APPENDIX C**Planning conditions that the Planning Authority would recommend in the event that An Bord Pleanála decides to grant permission, together with the reasons and grounds for such conditions**

Drawing file: Engineering Services / 21207-JBB-PH2-XX-DR-C-04009-Proposed SuDS Details.pdf

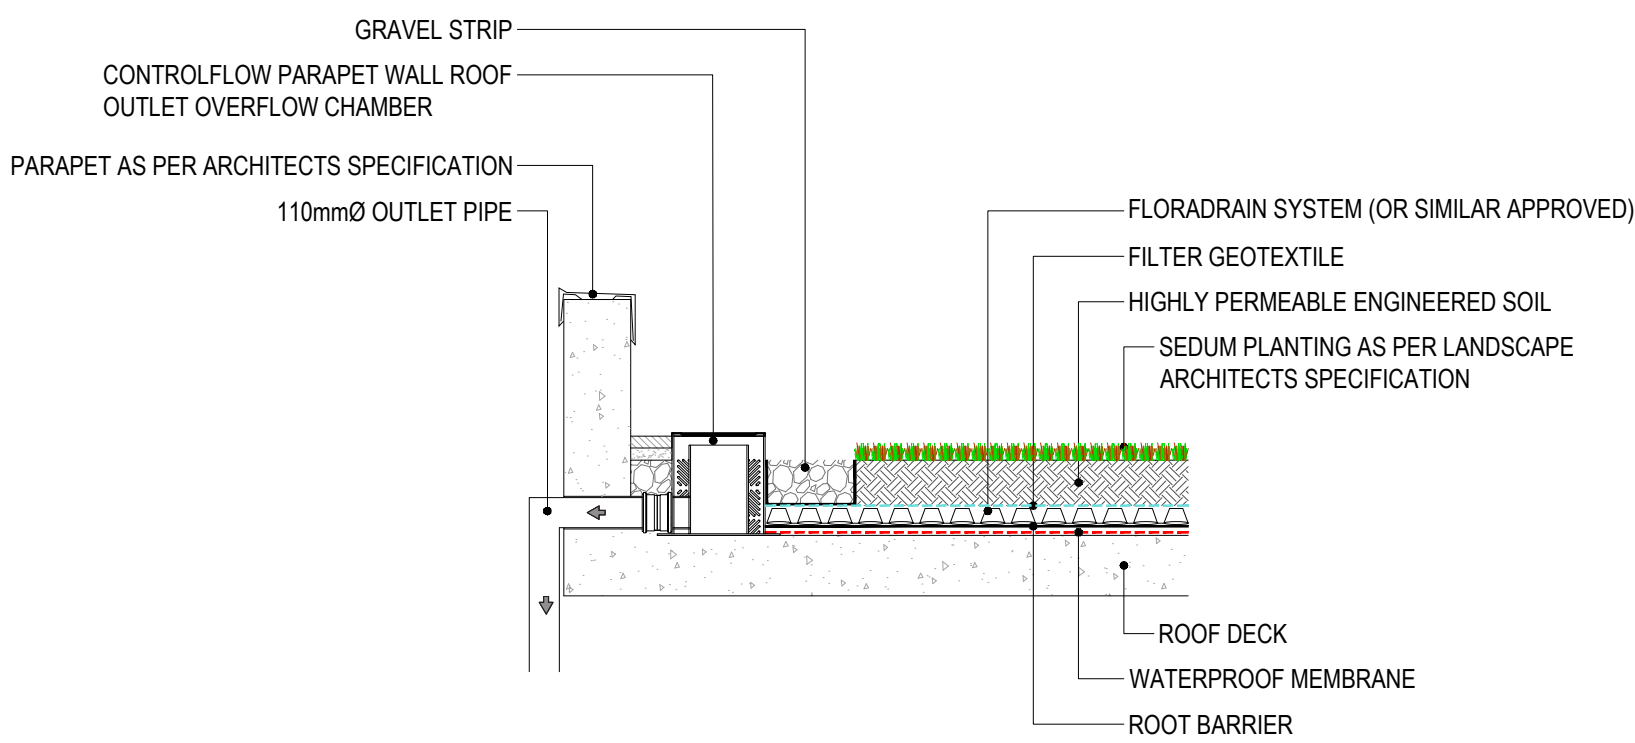
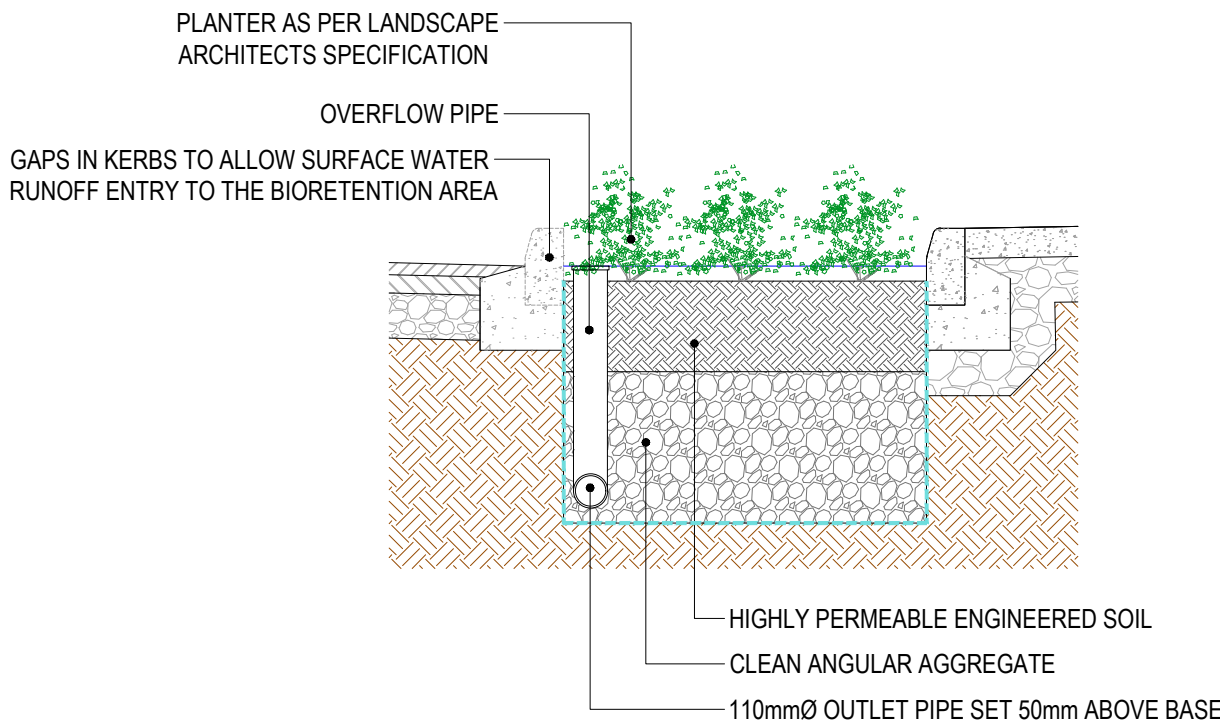
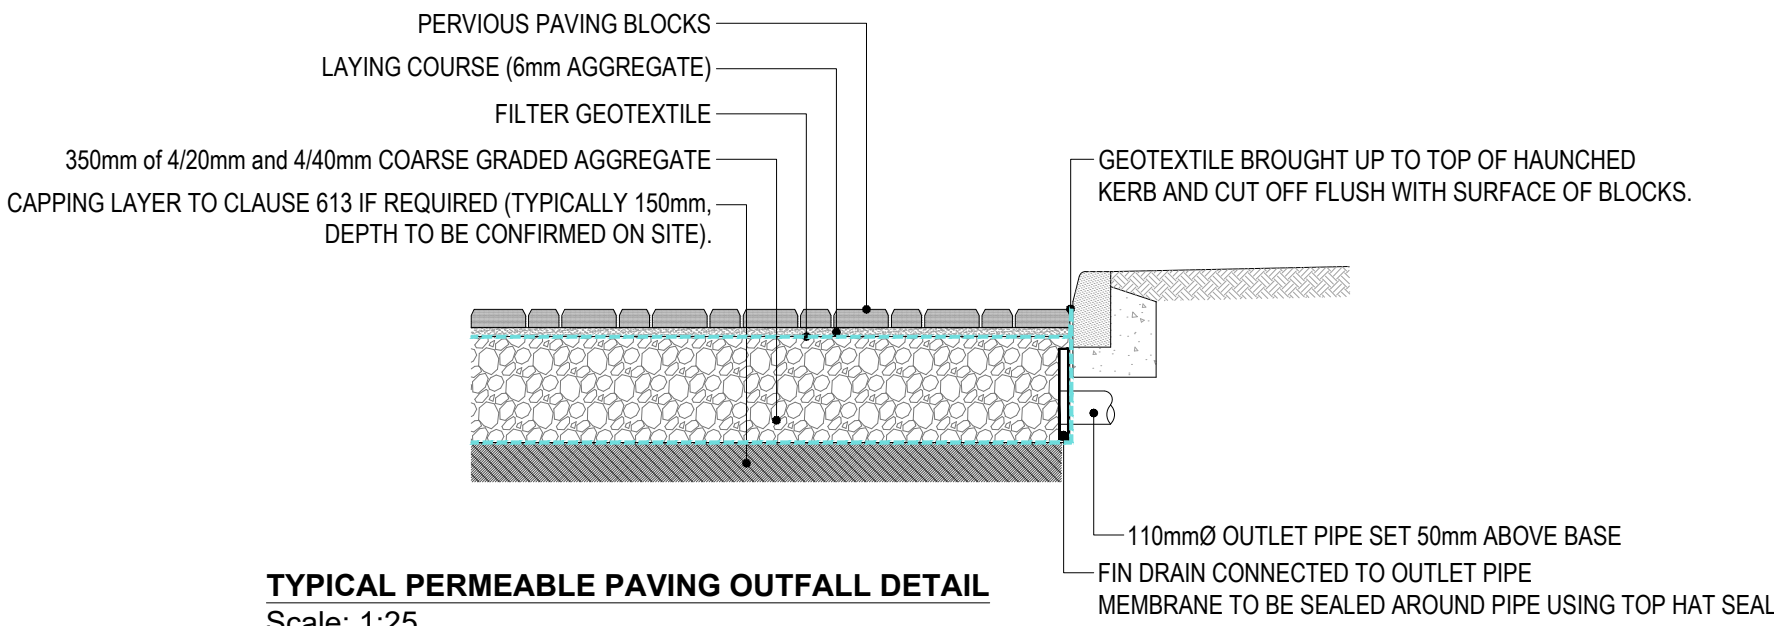
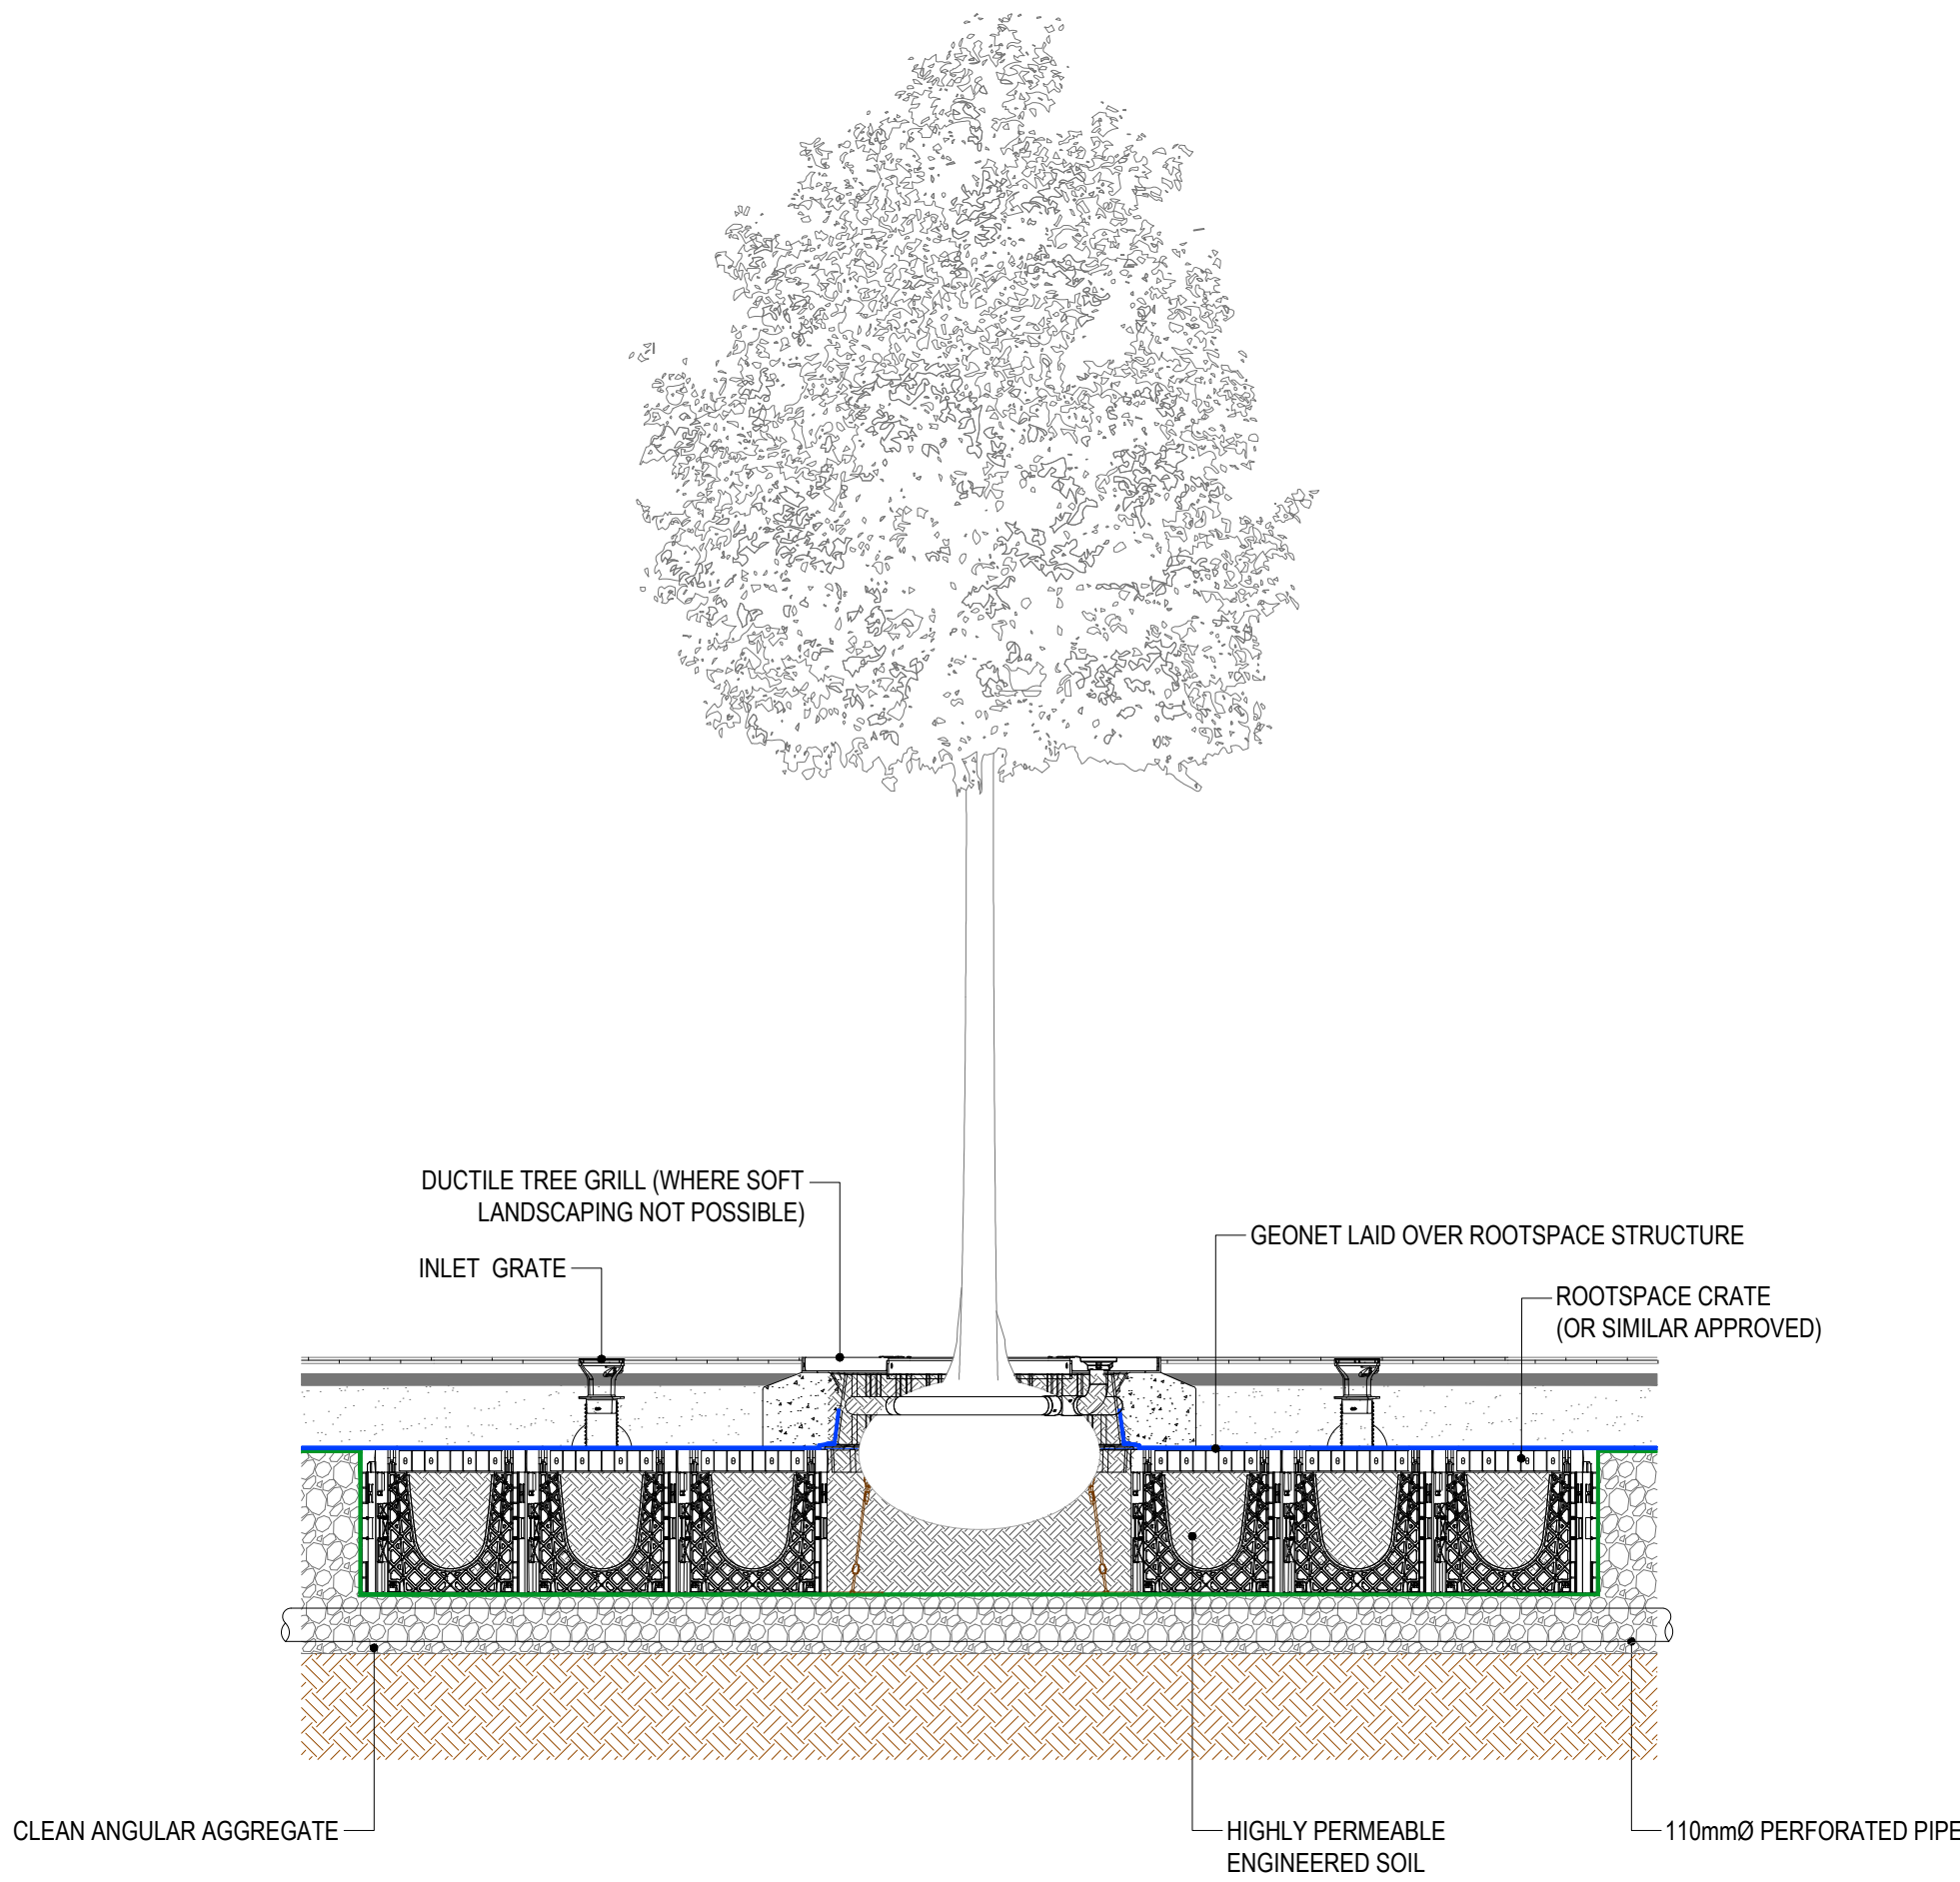
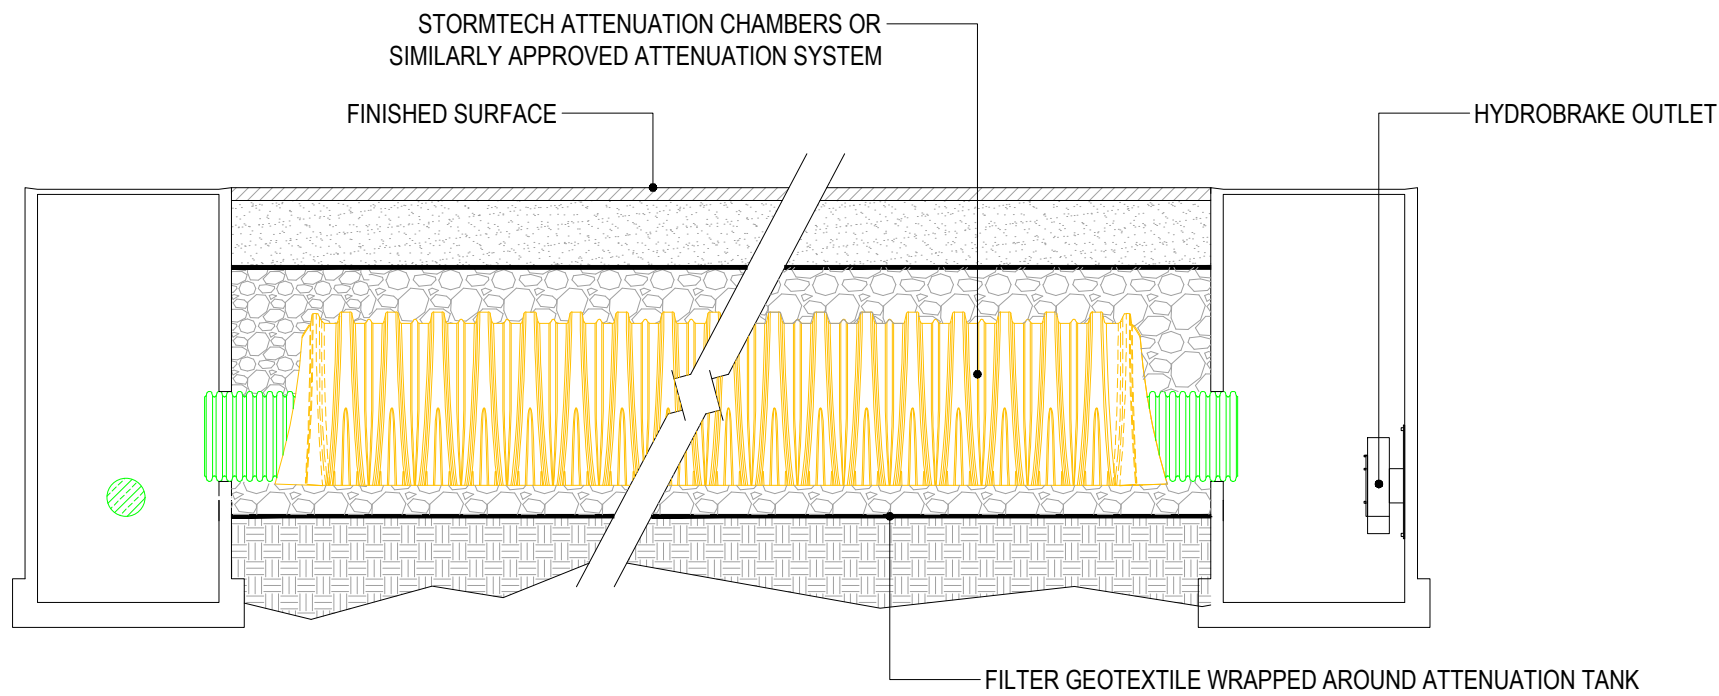
26. In finalising the SuDS strategy, the Applicant is requested to consider the following recommendations by the Planning Authority:

- Have regard to the recent Dept of Housing, Local Government and Heritage, interim guidance entitled: "Nature-based Solutions to the Management of Rainwater and Surface Water Runoff in Urban Areas".
- Coordinate the proposed SuDS measures into the landscape strategy. A combined SuDS & landscape layout, coordinating the landscape master plan (ref. IRLA-210604-2000) and the SuDS layout plan (ref. 21207-JBB-PH2-XX-DR-C-04005)) to be submitted to the Planning Authority for approval.
